**EPA Advice on Environmental Impact Statement –
MidCoast Regional Organics Facility – SSD-84090218**

I am writing in response to your request for the NSW Environment Protection Authority (EPA) to review the Environmental Impact Statement (EIS) for the proposed MidCoast Regional Organics Facility (Application SSD-84090218) at 48 Midge Orchid Road, Darawank, NSW, 2428.

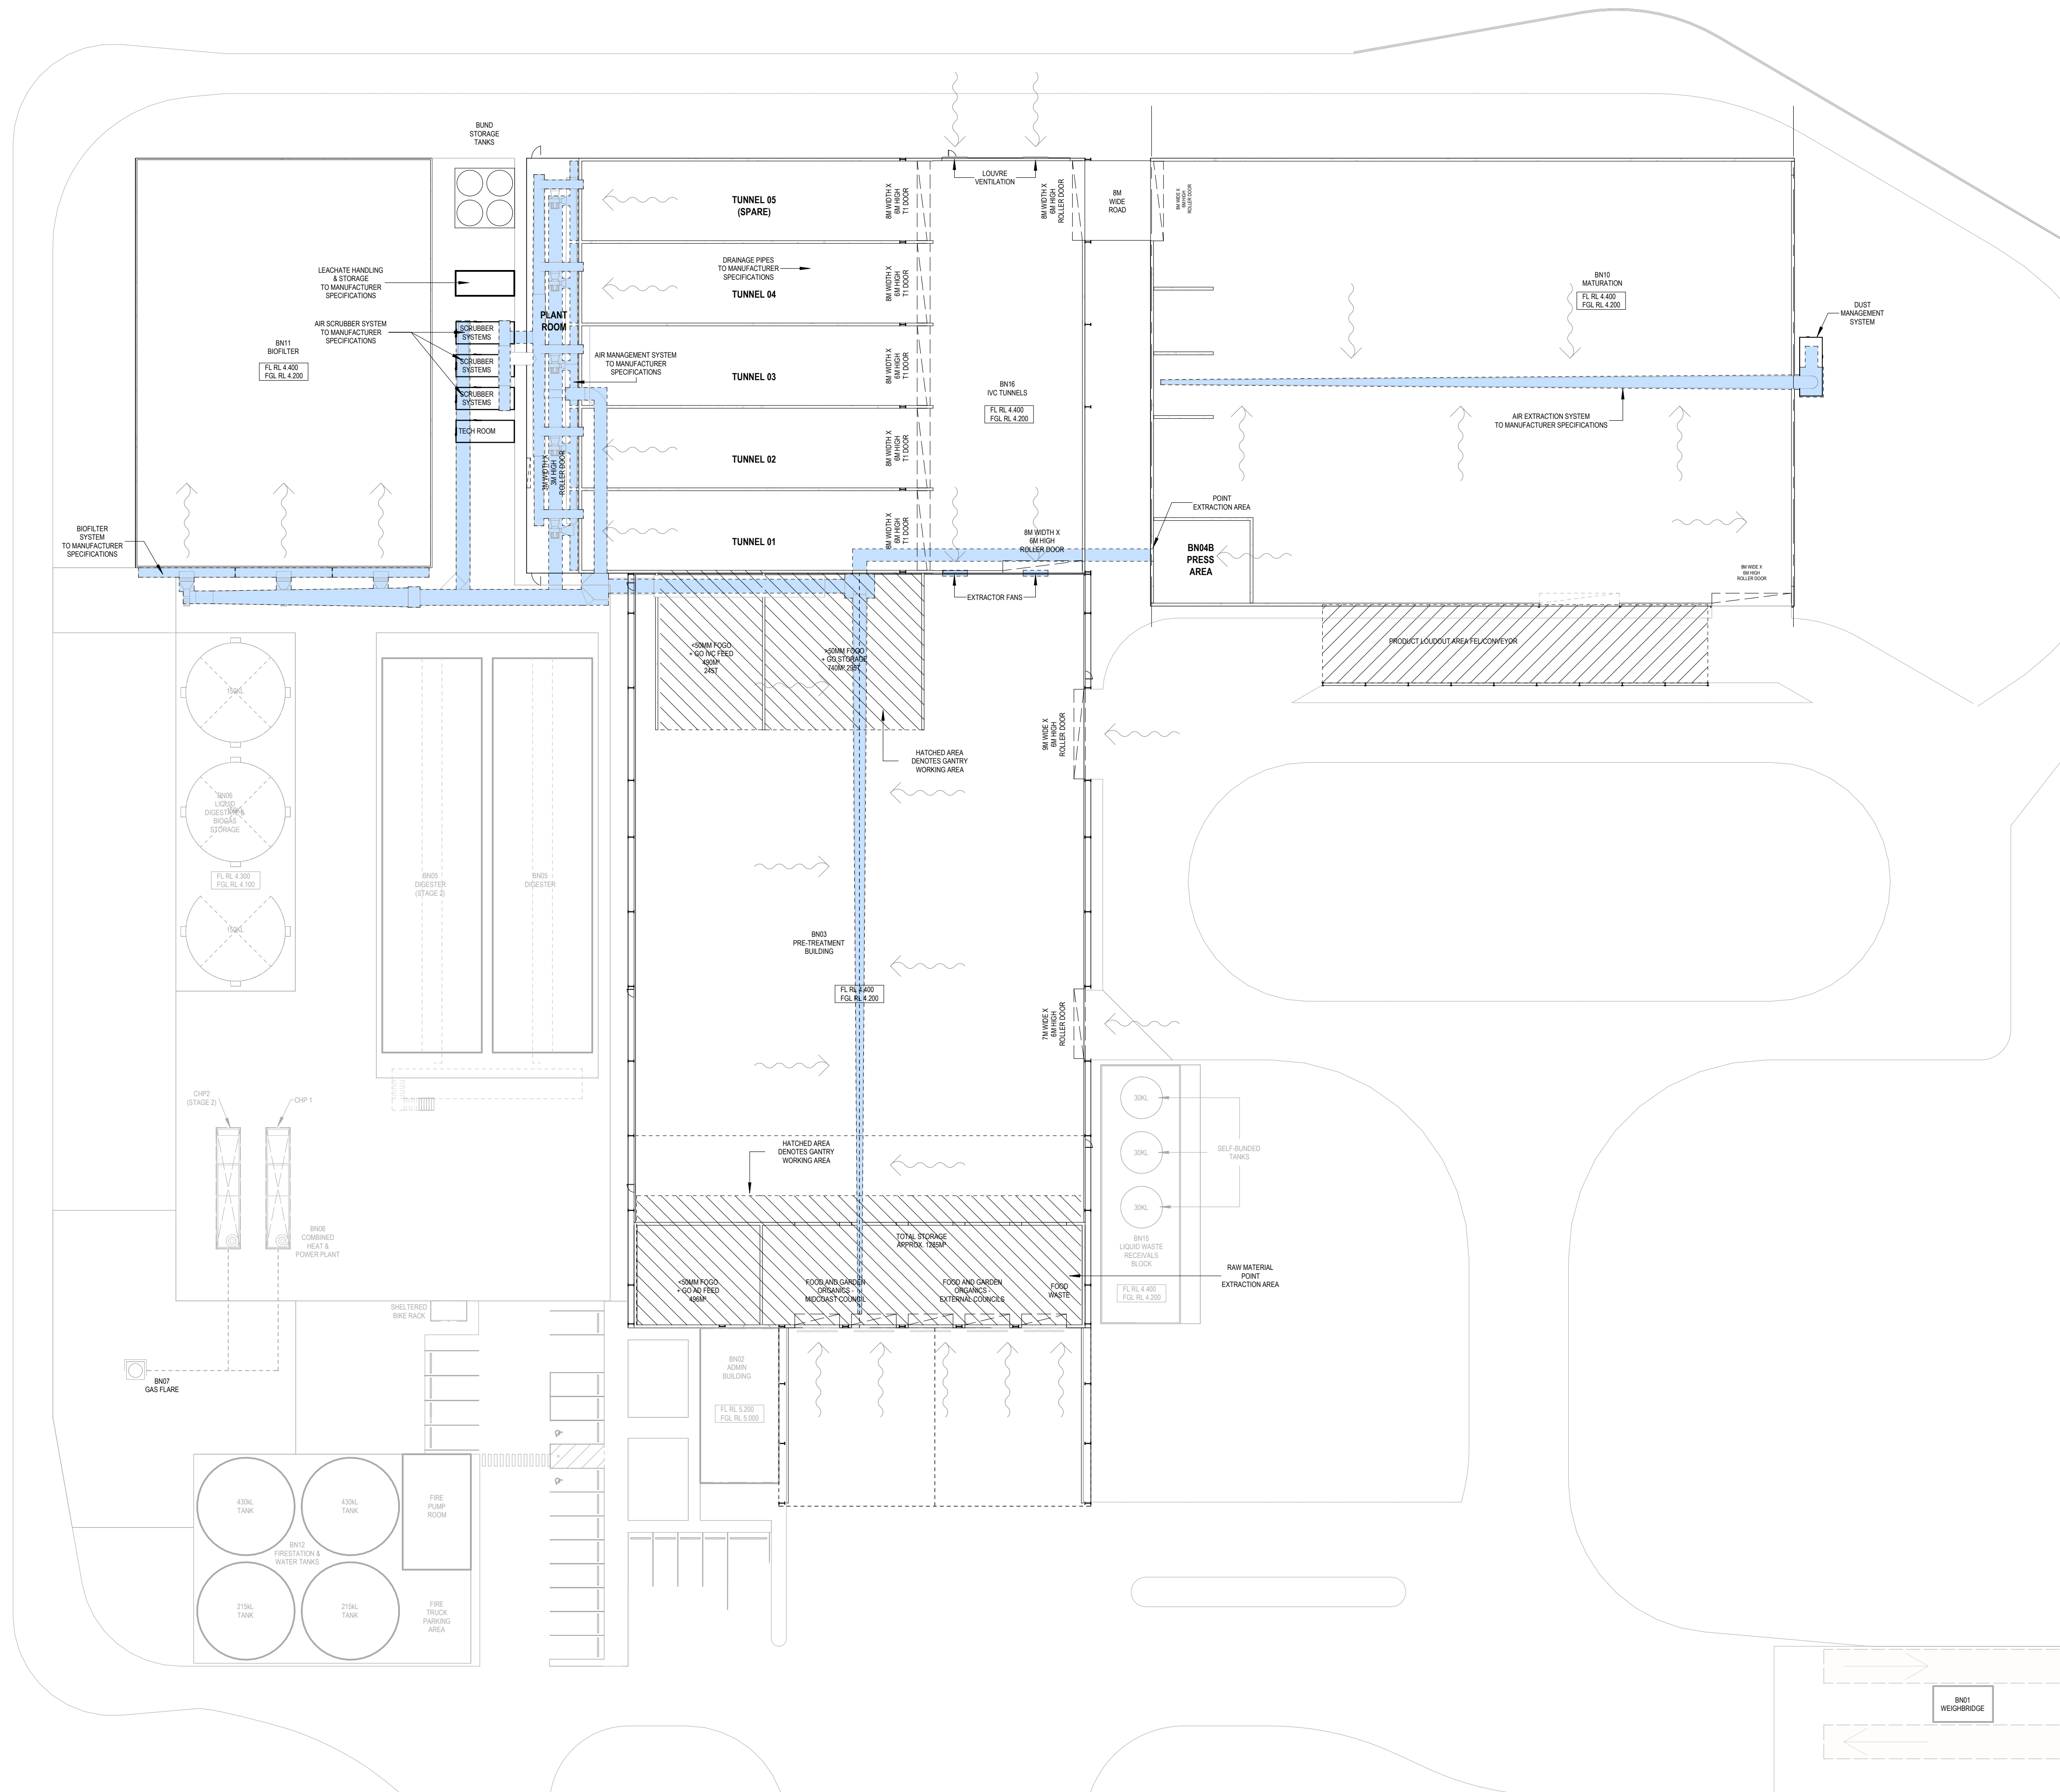
2. Identify on a site plan the location of fixed noise sources external to the process buildings, for example fan exhausts, blower intakes, combined heat and power unit (gas turbine) intake and exhaust and indicate how these noise sources were treated in the noise modelling.
